Our ref: HA/2014/115860/01-L01
Your ref: FP/109/14/PL
Date: 16 July 2014

**CONSTRUCTION OF AN UNMETALLED MAINTENANCE ACCESS TRACK
FORMER LEC AIRFIELD SOUTH OF FELPHAM WAY BERSTED PO22 8ED**

Environment Agency Position

title  
TEMPORARY BRIDGE OVER LIDSEY RIFE

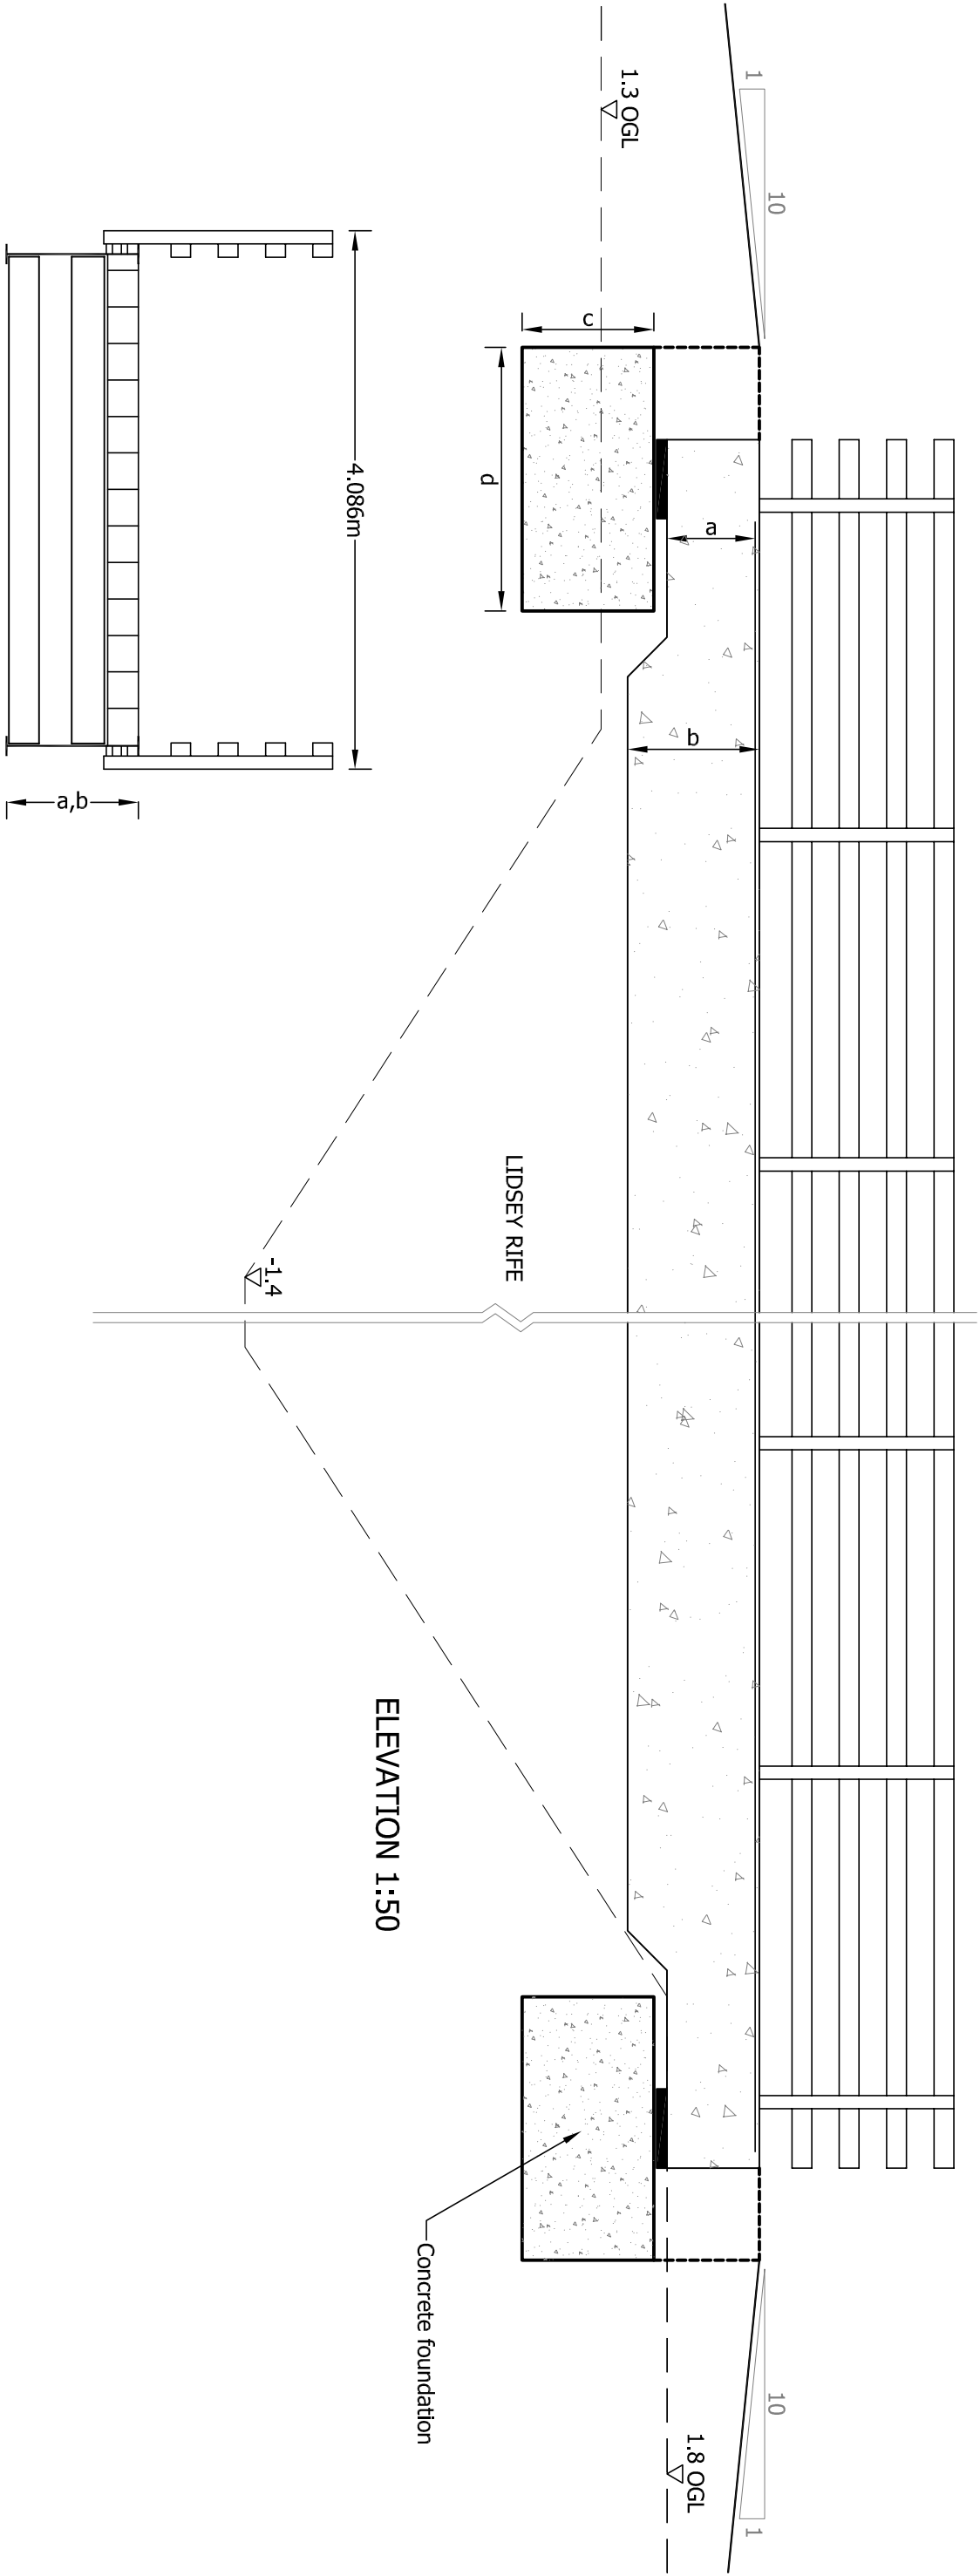
1. Temporary bridge should be clear span so that the soffit is no lower than existing banks.
2. Access track should be put in at existing ground level.
